## Sub1 Comments Response

Date: 03/31/23

Project Name: Yan & Guo Shoreline Exemption Permit (SHL23-201)

PIER DETAILS - EXISTING/PROPOSED PLAN VIEW

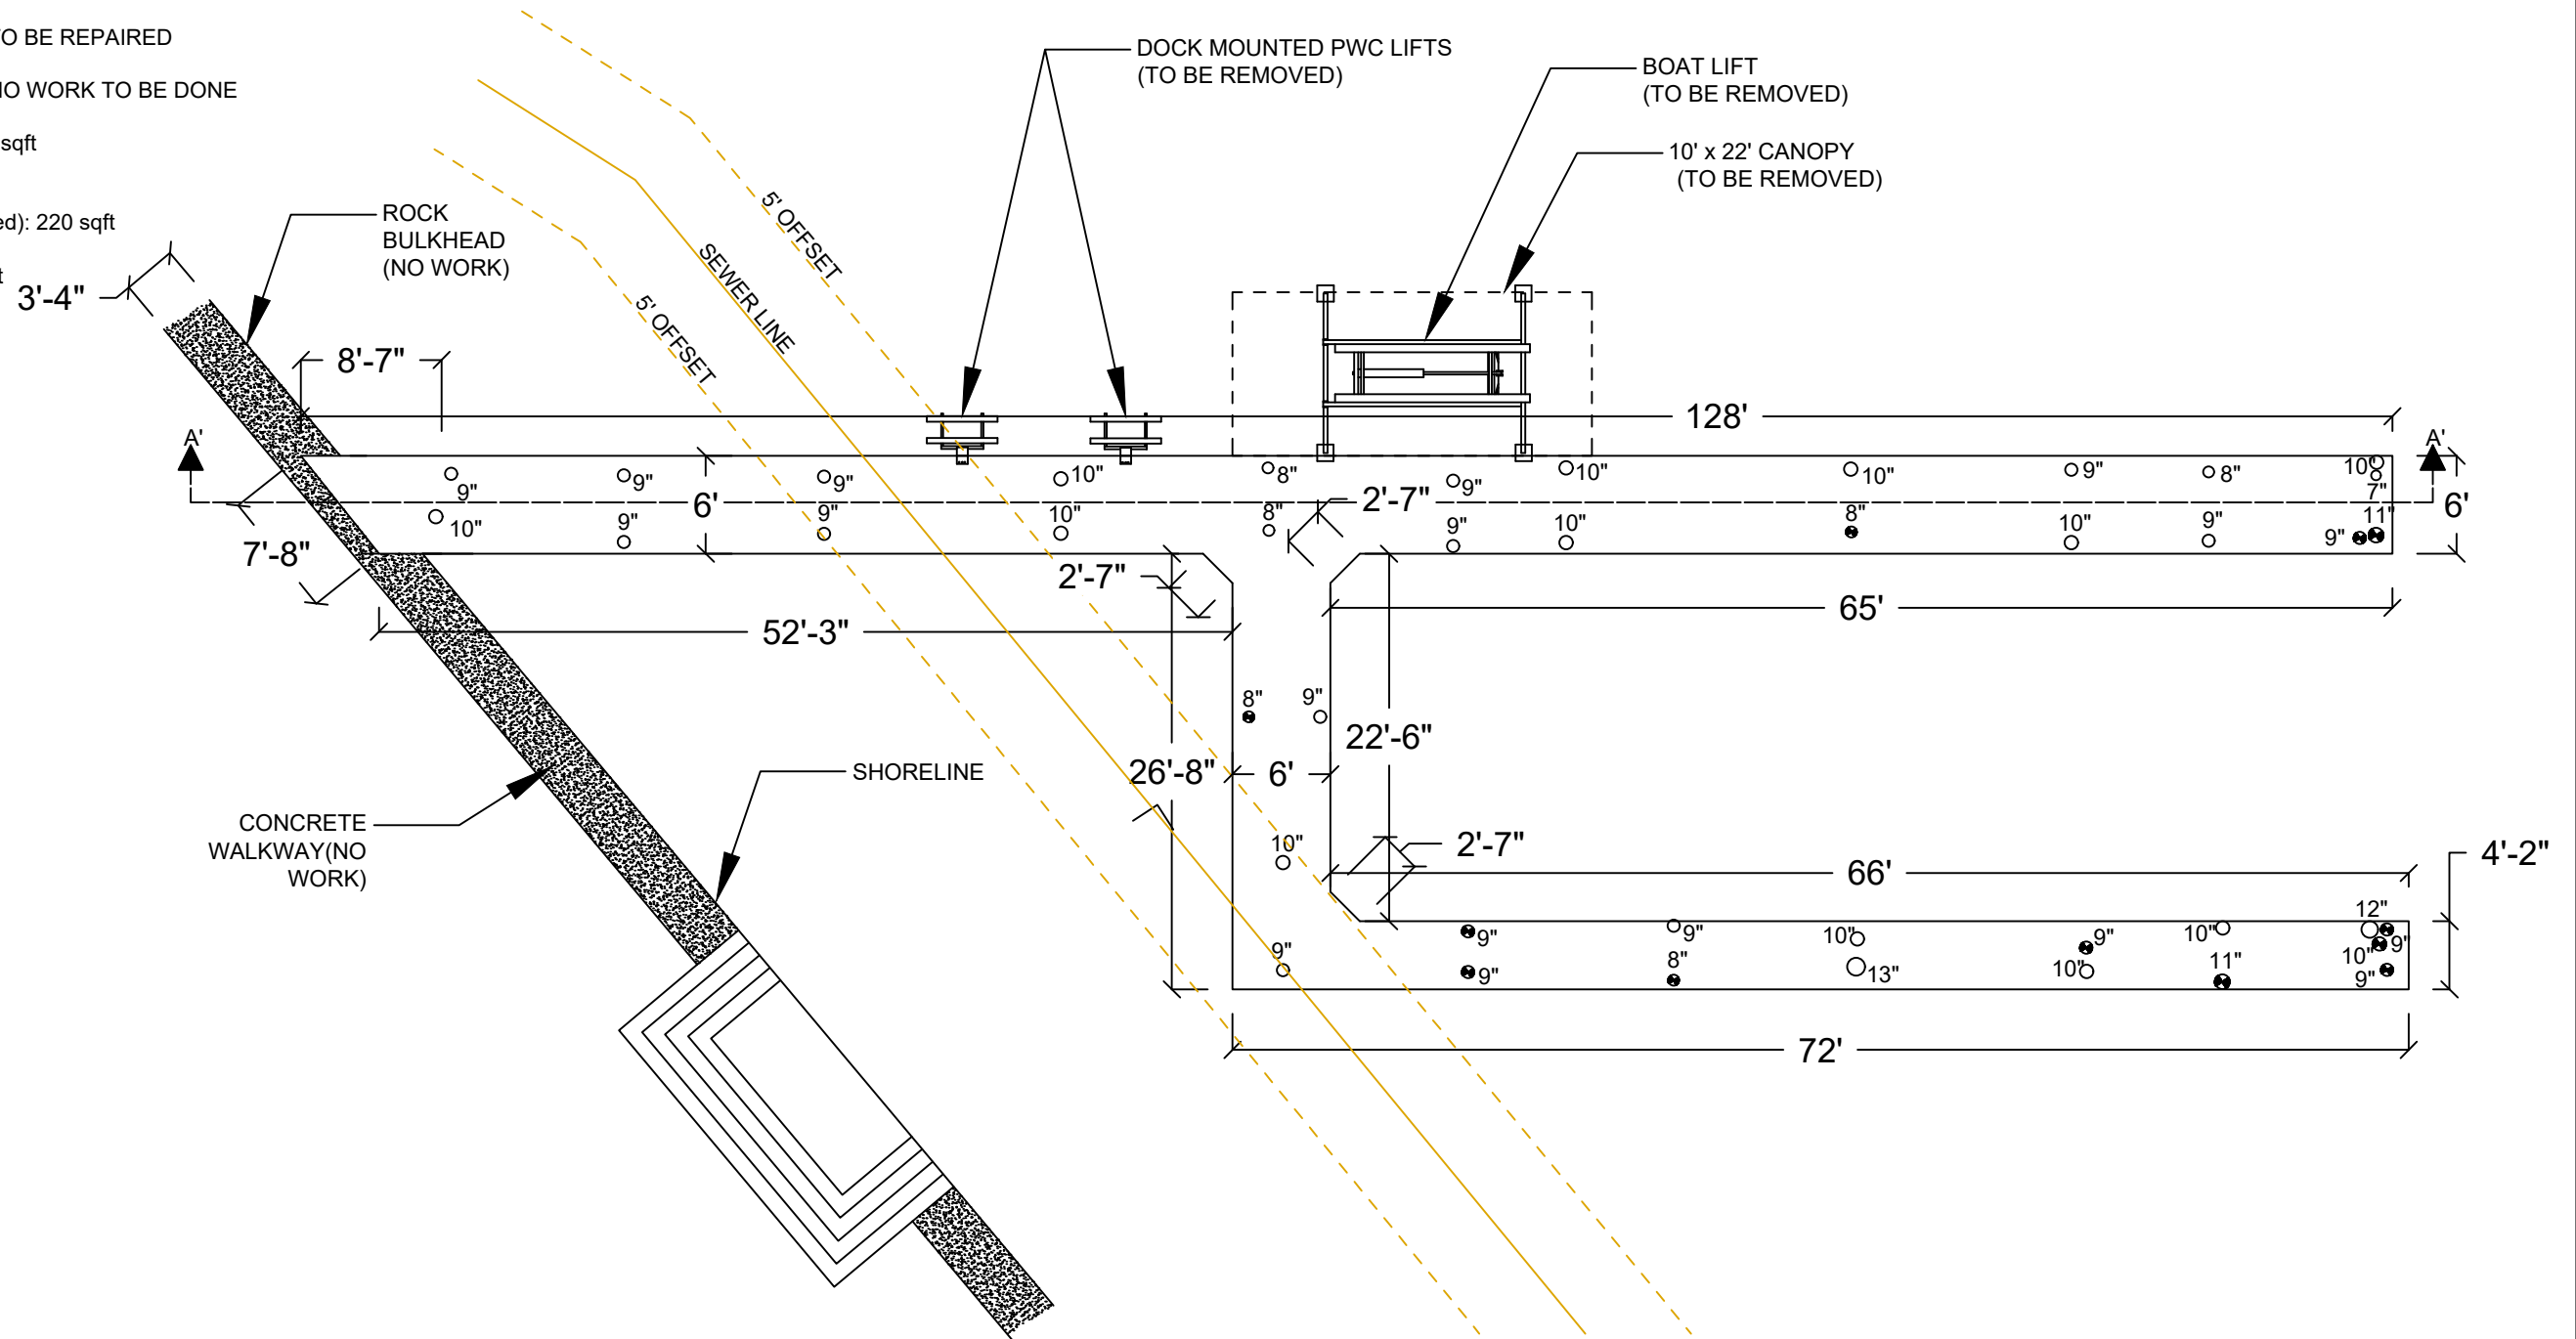
1. Show how the project meets the criteria of one of the exemptions listed in WAC 173-27-040, and is therefore exempt from needing a Shoreline Substantial Development Permit.

**Our proposed repair of (12) existing piles are due to their current unsafe level of decay. The repair to the existing piles will be stronger than original condition without exceeding the original size, shape, configuration, or location. Removing the (2) dock mounted PWC lifts along with the (1) existing boat lift with the attached canopy only improves the area by reducing the overwater coverage and does not affect the structure of the dock.**
